Please ask for: Ms Iqraa Malik
Email: iqraa.malik@terraquest.co.uk
Telephone: 01212341390
Our Ref: LU/139/21/HH
Your Ref:
Date: 28th April 2021

Application for Planning Permission for Works or Extension to a Dwelling

Development: Installation of a first floor rear balcony
Location: 5 Shannon Close Littlehampton BN17 6PR

PLAN VIEWS OF FLAT ROOF
OF REAR EXTENSION CONVERSION LU/139/21/HH
Scale 1:100
Drawn by R GATCHER DATE 8/6/21

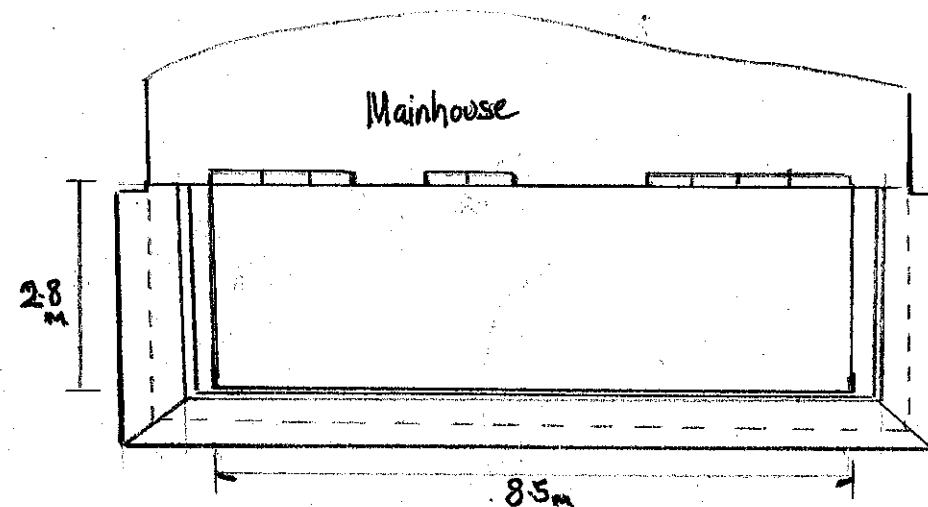
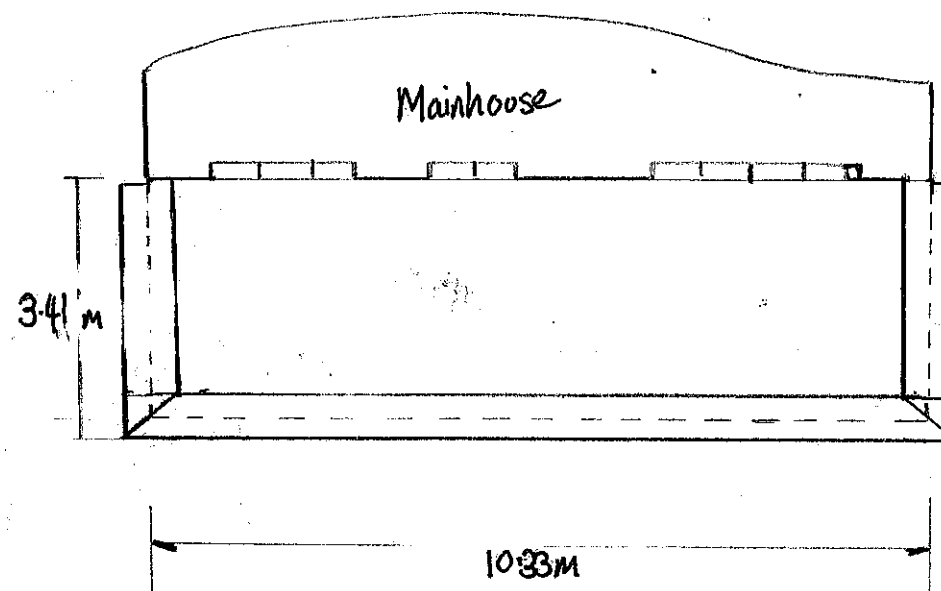
Please submit 1 electronic or 3 paper copies of clearly labelled existing and proposed first floor floor plans at a scale of 1:50 or 1:100. Further details can be found in the Validation Requirements List.

Elevation Plans LO/139/21/HH
Scale 1:100 Drawn by R. GOATCHER

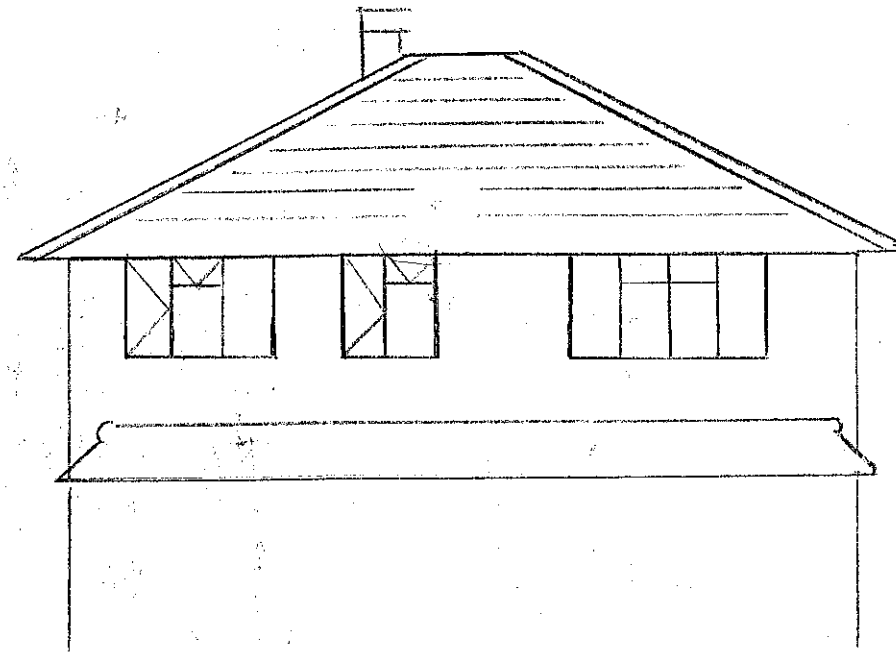
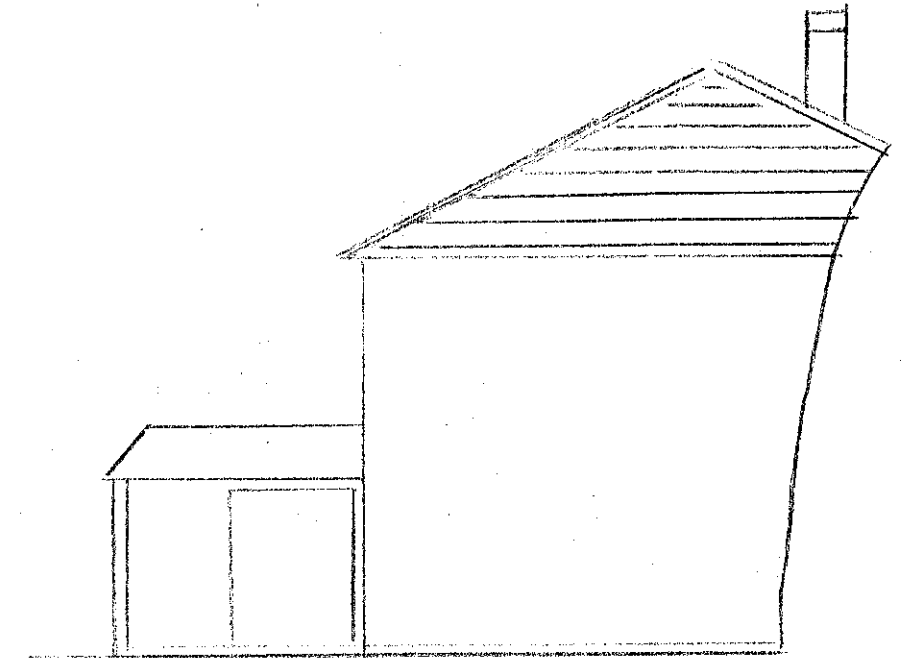
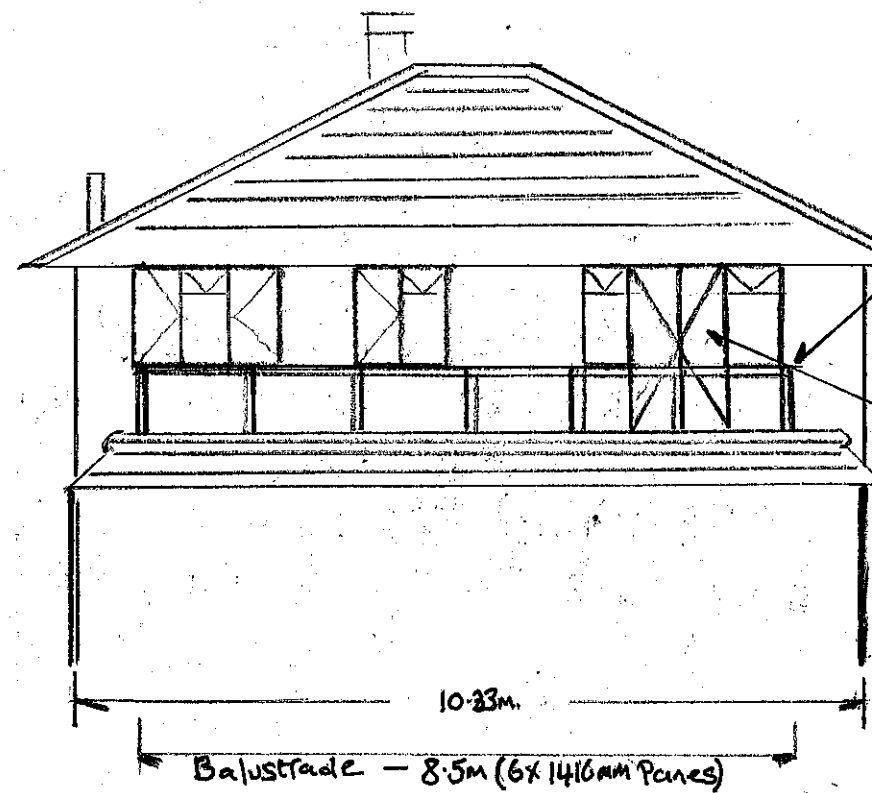
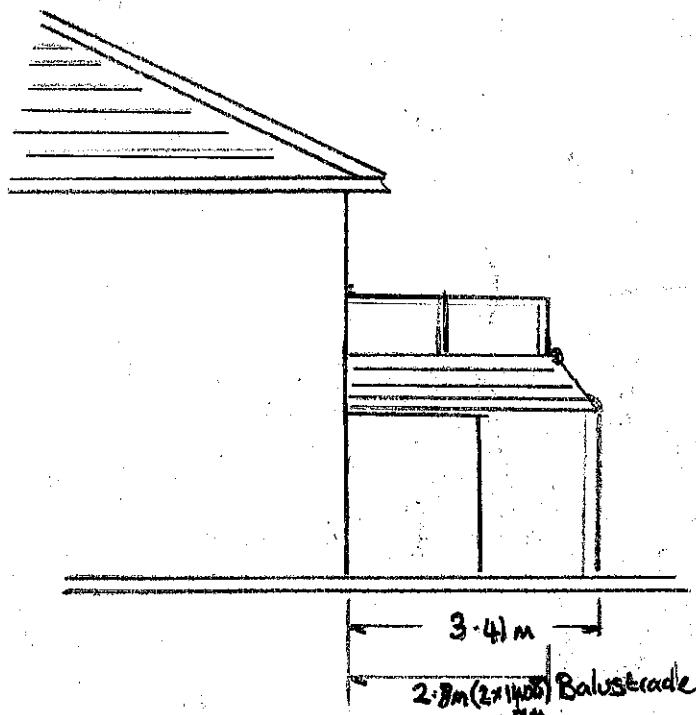
Please submit 1 electronic or 3 paper copies of clearly labelled existing and proposed elevations at a scale of 1:50 or 1:100. Further details can be found in the Validation Requirements List.

5 Shannon Close

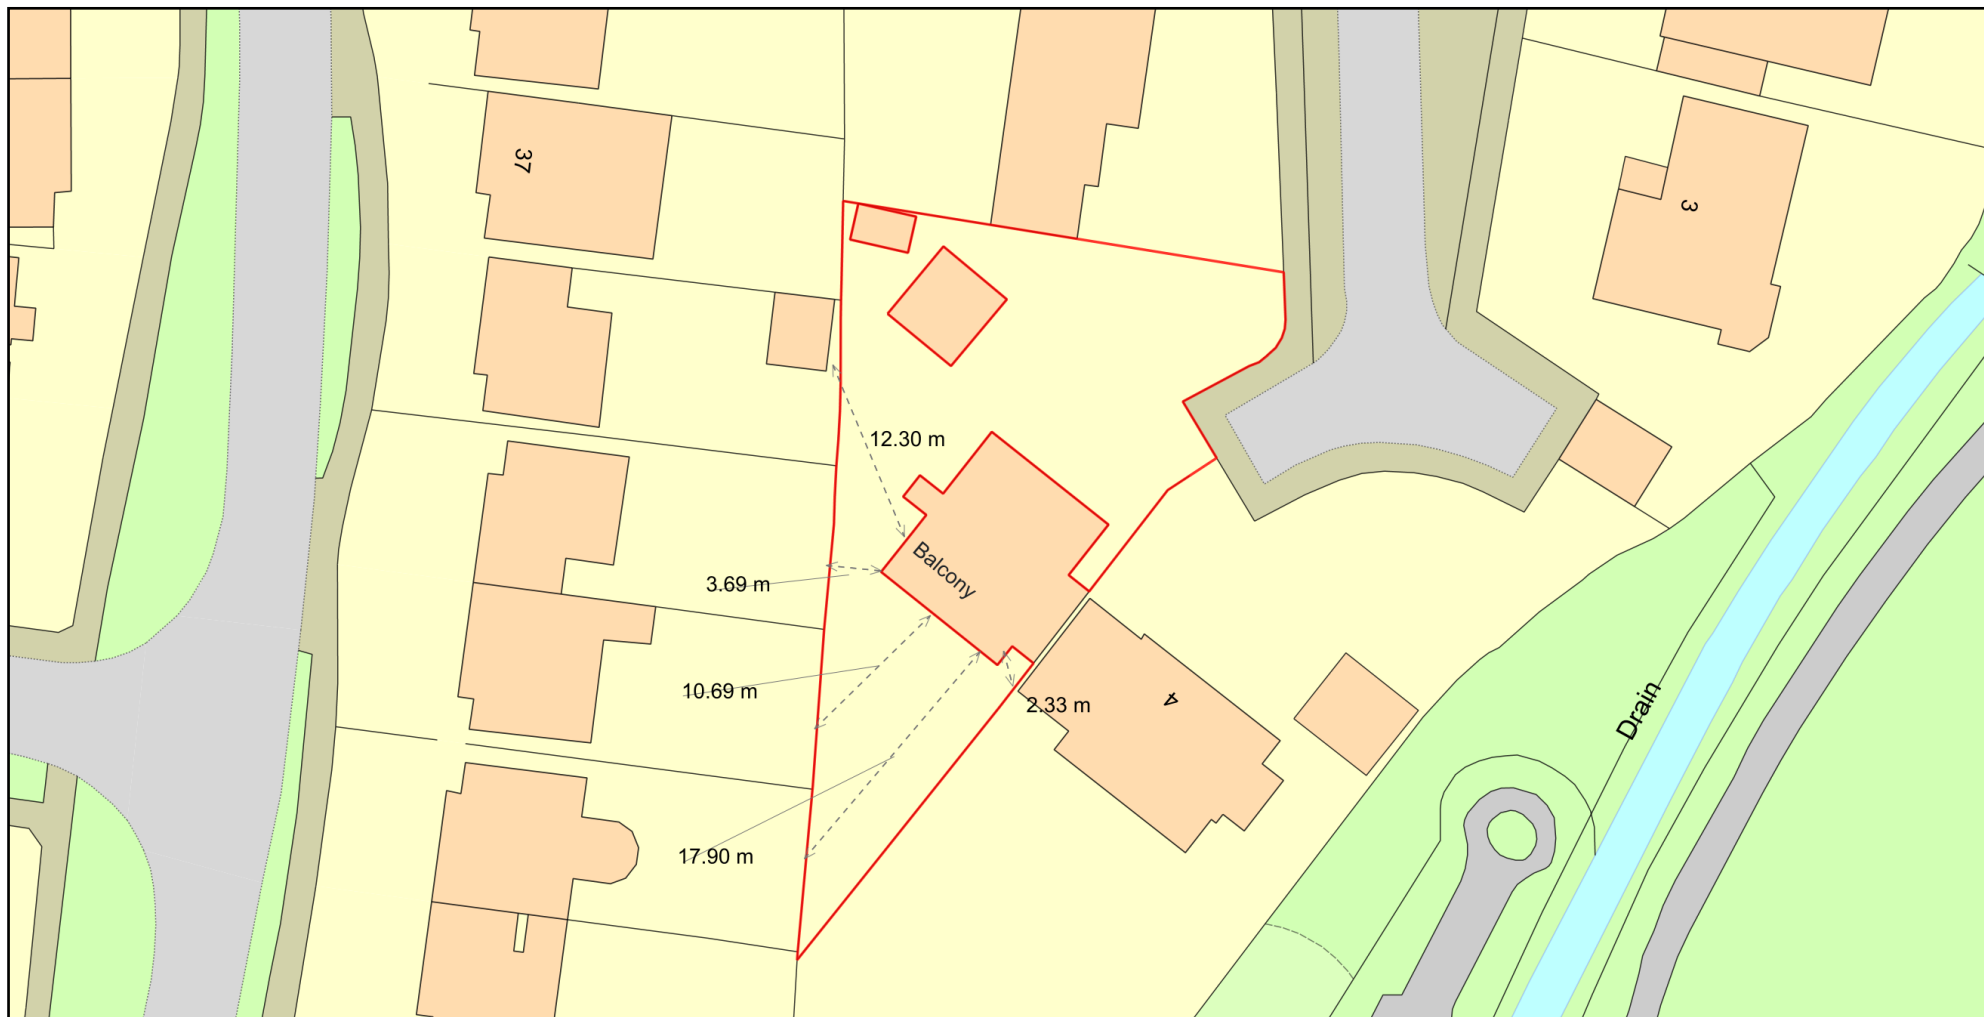
Please add a scale bar and dimensions from the proposed extension to all site boundaries on your block plan. Further details of what must be included on the plan can be found in the Validation Requirements List.
